Response to Planning application from Hertfordshire County Council (T and CP GDP Order 2015)

District ref: 6/2017/2105/RM

Plot 4100 Gypsy Moth Avenue

Approval of reserved matters (access, appearance, landscaping, layout and scale) for the erection of two motor retail showrooms and valet building with associated parking and landscaping of the approved outline planning permission 6/2015/2043/OUTLINE, dated 05/07/2017

Drawing title	Status, Drawing number & revision	Amendments
Proposed Site Plan	3280/ 030 M	Planning - Material Amendments
Drawn by	Checked by	A1 Scale
EM	JA	As indicated
		A3 Scale
		Date
		14/06/2018
		14:31:20
		Status
		PLANNING

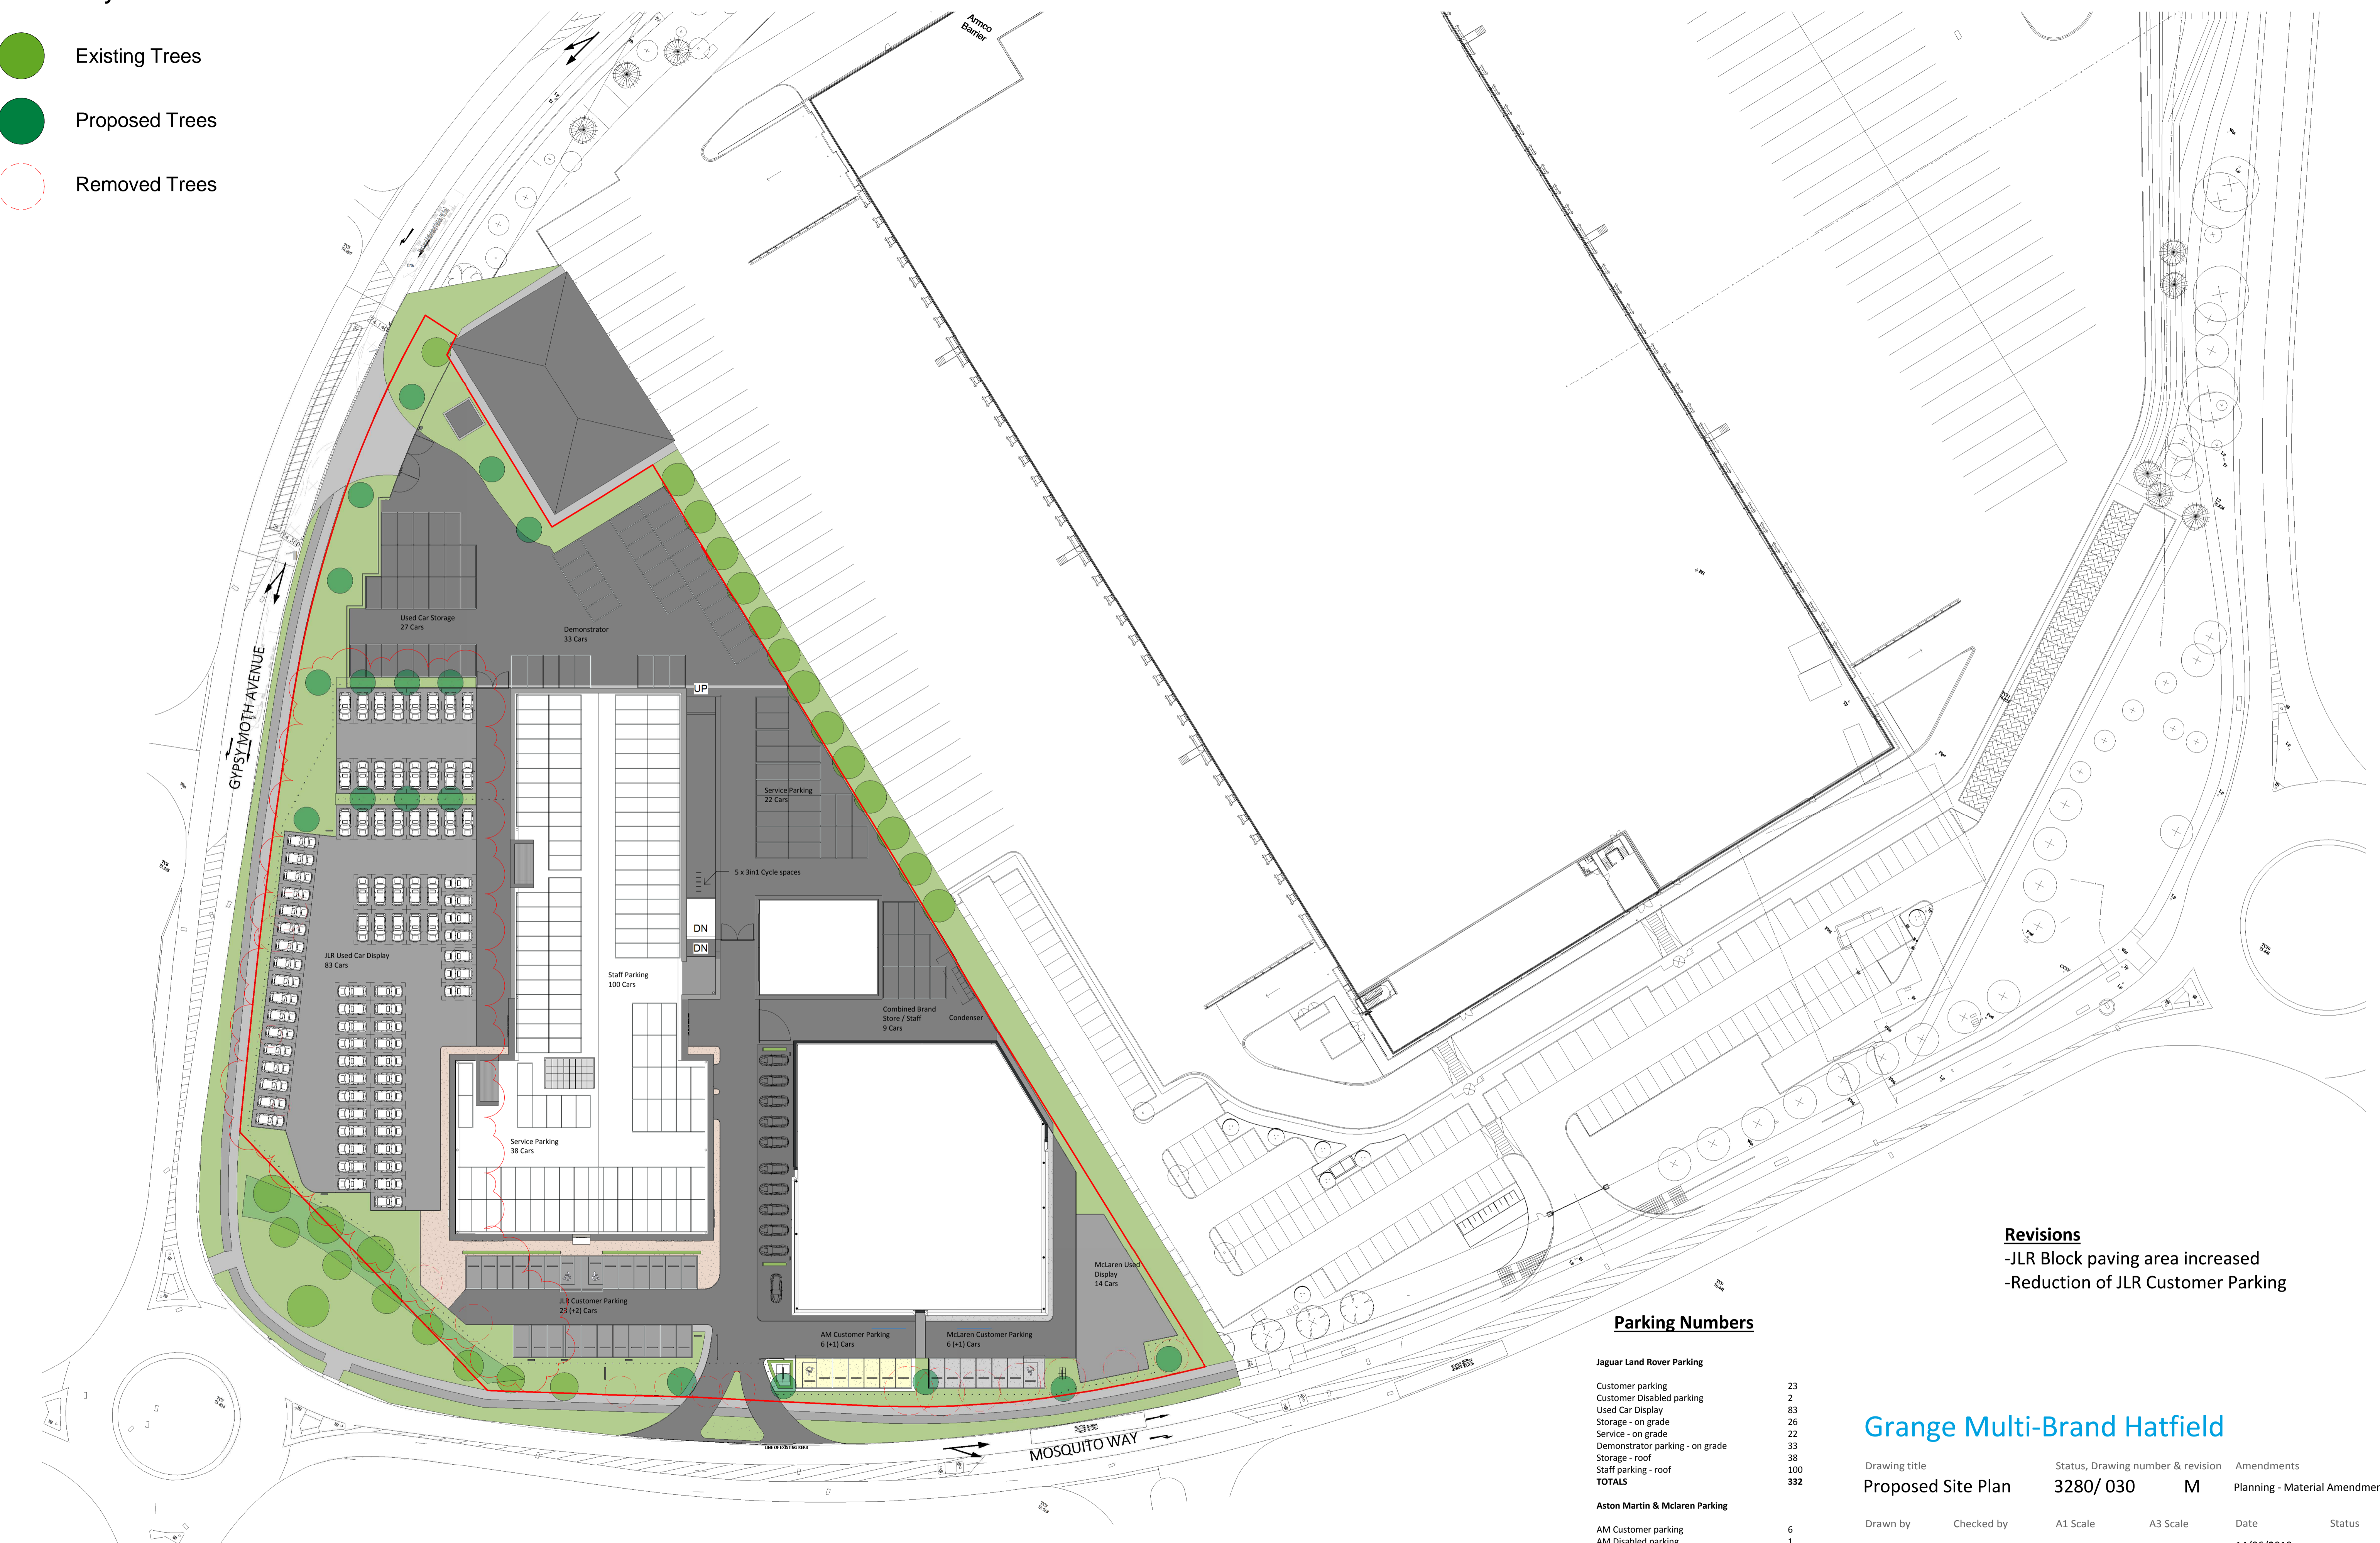
The applicant submits, in respect of reserved matters, revised site layout (Proposed Site Plan 3280/ 030). The accesses, as shown, respect that agreed in principle at Outline, however fails to provide further details necessary in respect of the new access to demonstrate to the Highway Authority that the access is appropriate.

Drawing 3280 / 030 appears to have some detail in respect of swept paths of large vehicles (shown adjacent to the existing access on Gypsy Moth Avenue) however this swept path information is not visible beyond the extent of the carriageway, and therefore fails to demonstrate that the gate alignment and internal route configuration is appropriate to enable access for larger vehicles. It has previously been observed that the formation of access on Mosquito Way will necessitate the relocation of bus cage, and whilst drawing 3280/030 does provide details of a proposed solution in this matter, it shall require vehicles overtaking a stationary vehicle using the dedicated right hand turn lane, such a situation occurs to the north of Gypsy Moth Lane without evidence that it has resulted in problems. It is considered all such matters would be expected to be dealt with in respect of discharging condition 5 of the outline consent

Noting that the layout of the site is a matter on upon which the reserved matters is sought, HCC would expect to see that the site provides adequately for turning of vehicles associated with its use within the site. Noting the car retail use proposed, it is not unreasonable to expect pantechnicons delivering vehicles and unclear whether the site layout permits vehicles to manoeuvre within the site in order that they may exit in forward gear, or provide opportunities within the site for turning. The Boroughs own District Plan SPD supplements Policy D1 Quality of Design in the District Plan stating that all new developments should incorporate adequate provision for access and servicing which meet the requirements of the local highway authority. Sites across the Business Park provide for turning of operational service vehicles within the sites and loading / unloading of deliveries. It is considered reasonable to expect that car transporters shall be used to deliver vehicles to the showroom, and therefore details should be provided in respect of arrangements for on-site deliveries in order to ensure that disruption to public transport and other highway users does not occur.

Double yellow restrictions would not prevent pantechnicons loading / unloading within Gypsy Moth Lane, interfering with the safe operation of the dedicated right hand turns along its' length if unable to access the site. Similarly, loading / unloading activity on Mosquito Way may prejudice the safety locally. It is unclear whether the parking and access arrangements within the site permit access and manoeuvring of such vehicles.

The Highway Authority are unable to assess the impacts of the development in respect of deliveries to the site, and therefore request that such information be provided.
